Planning Inspectorate
BUCKINGHAM AVENUE, SLOUGH, SL1
4PN

Reference: OR-0007684/01
Customer reference: EN0110013

**Deadline 2 submissions response letter
The Droves Solar Farm**

This letter constitutes the Environment Agency's Deadline 3 response regarding the Deadline 2 submissions. Please see:

DRAWING TITLE:
ES Figure 12.13 Work No. 2 Piling Locations within CSA for Maximum Groundwater Level

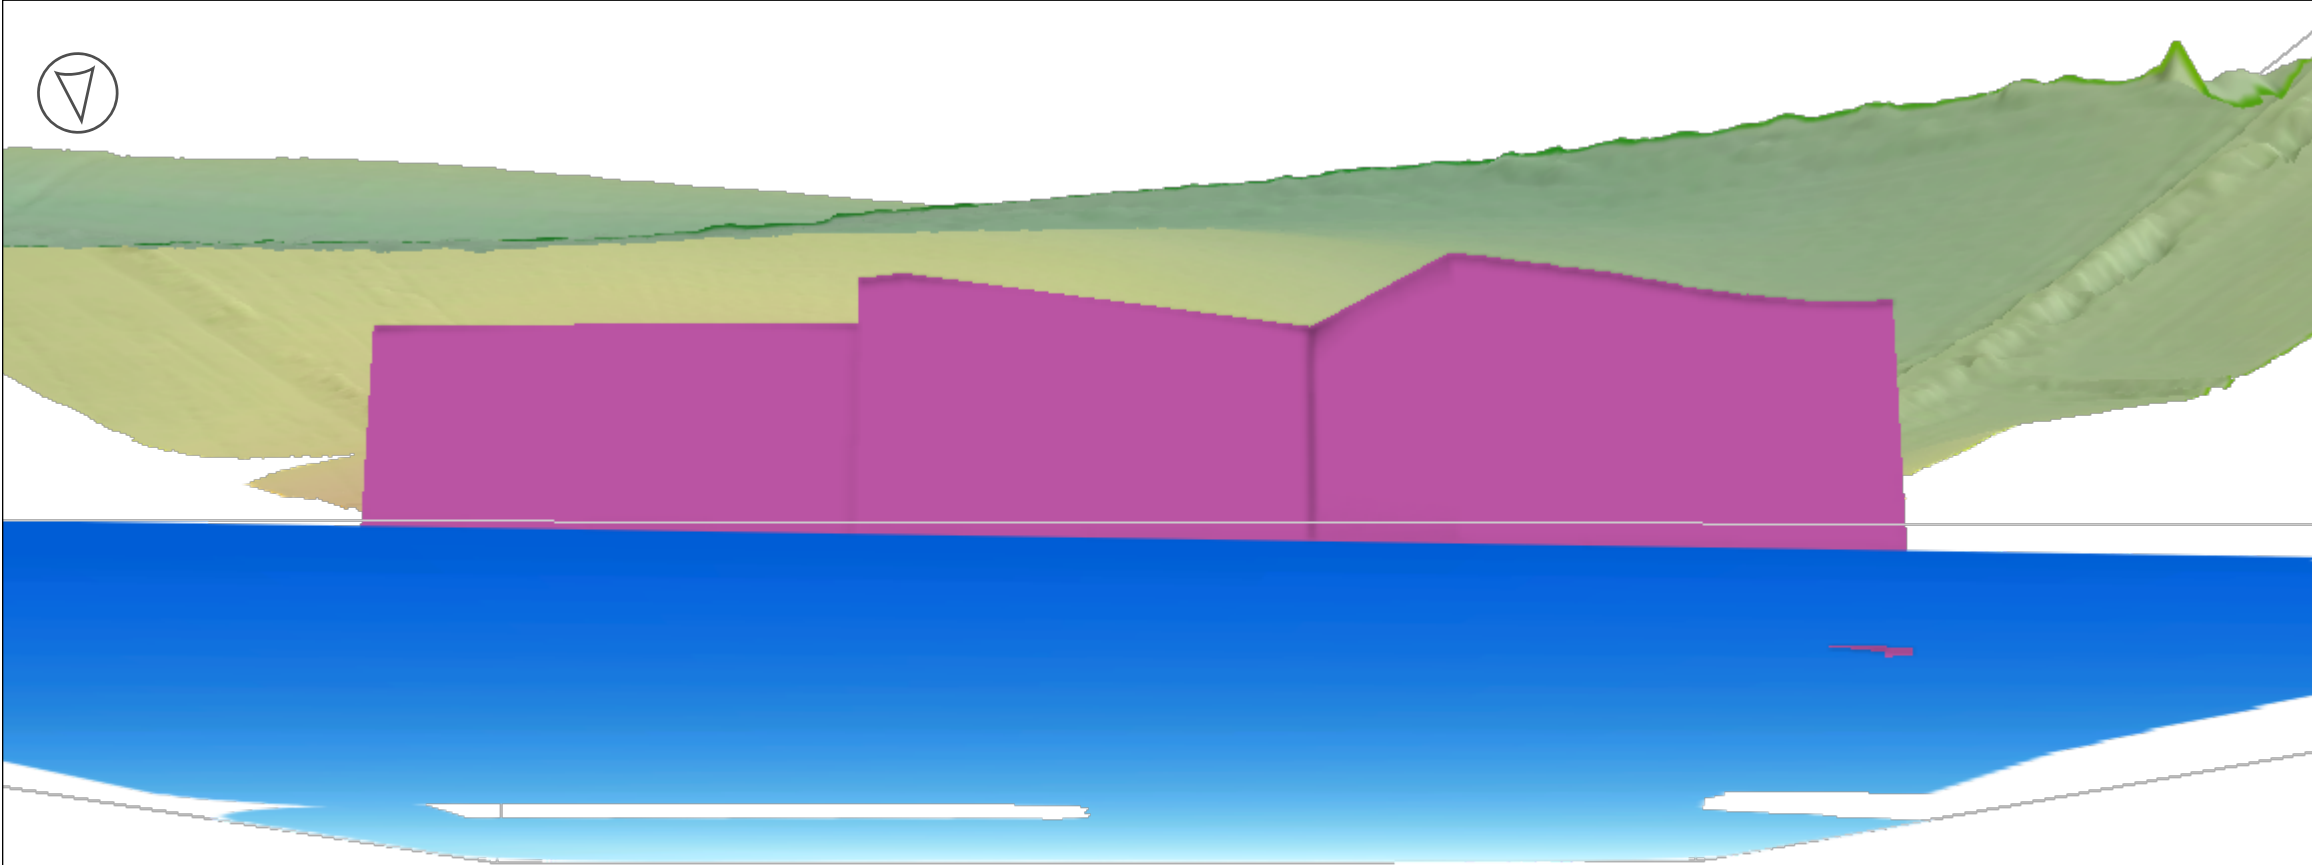
We were concerned that figures 12.13 [\[APP-127\]](#), 12.14 [\[APP-128\]](#), 12.15 [\[APP-129\]](#) and 12.16 [\[APP-130\]](#) do not clearly define the area represented by the drawings, including view orientation, or the elevation values.

We are unable to find any amended figures in the updated documents.

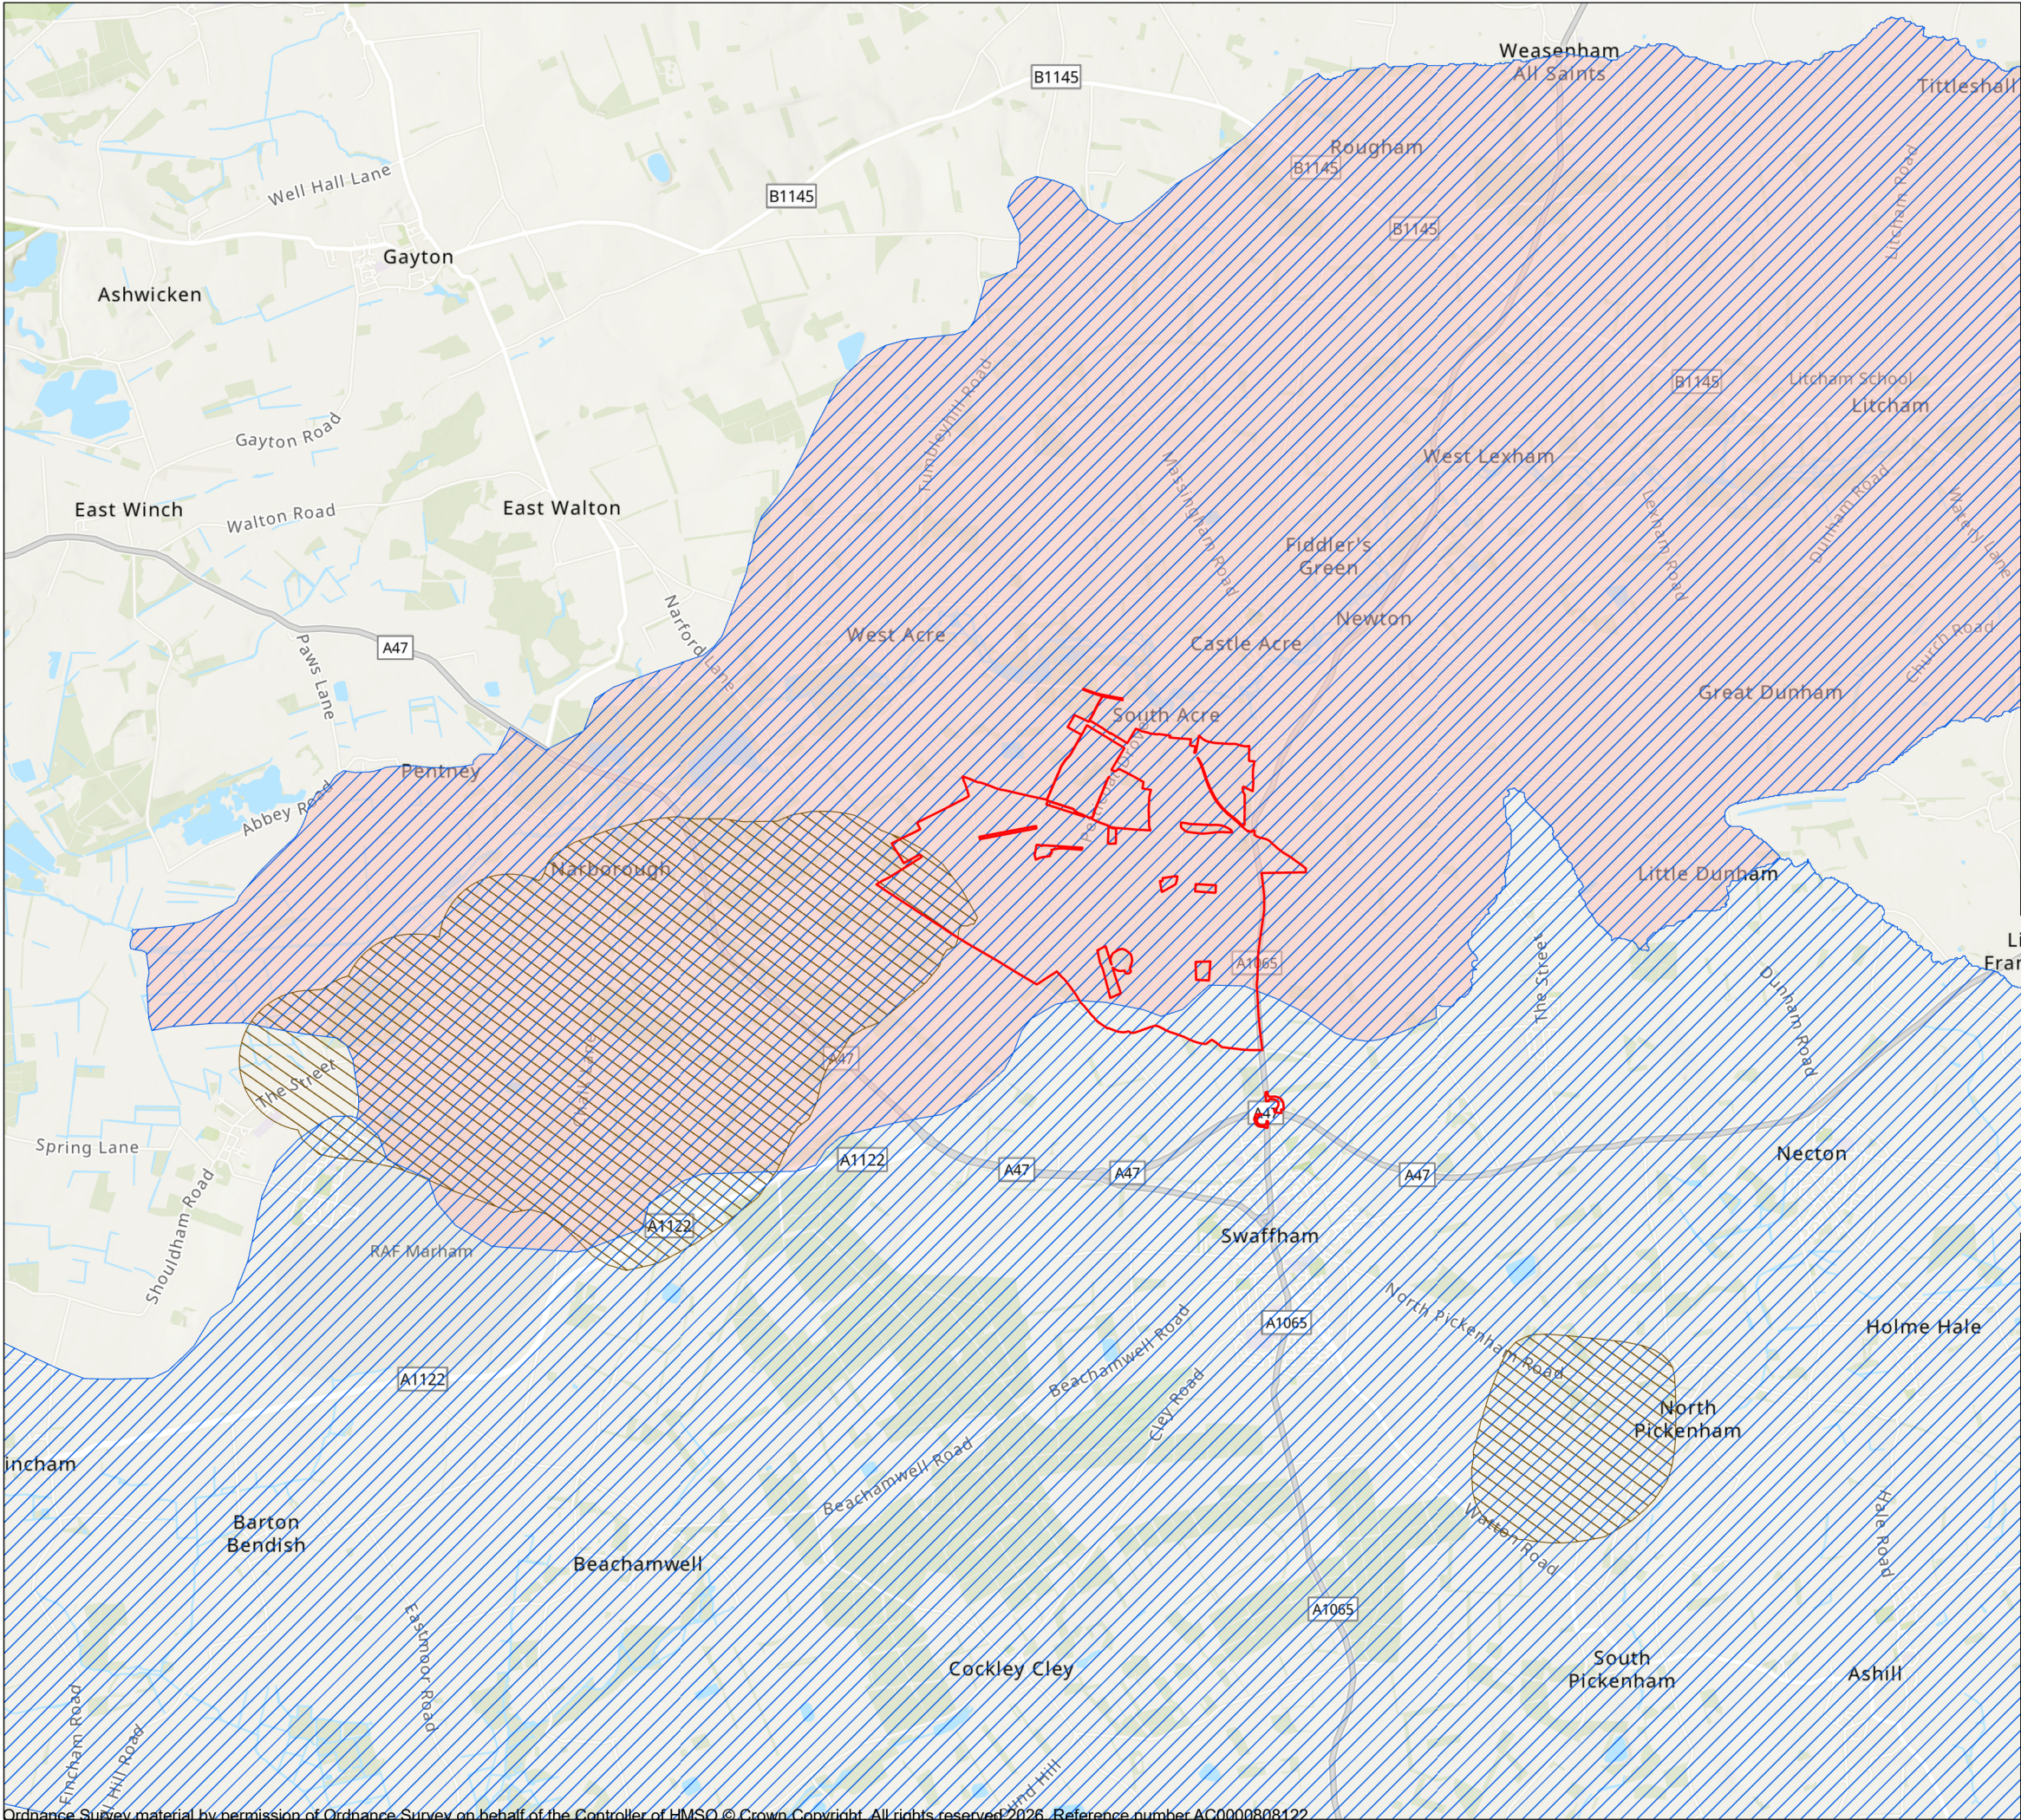
We were concerned that Figure 12.12 [\[APP-126\]](#) does not show all of the drinking water protection designations, including the Drinking Water Surface Water Safeguard Zone and Drinking Water Groundwater Safeguard Zone. The reader is therefore unable to see these designations in the context of the draft Order Limits.

We are unable to find any amended figures in the updated documents.
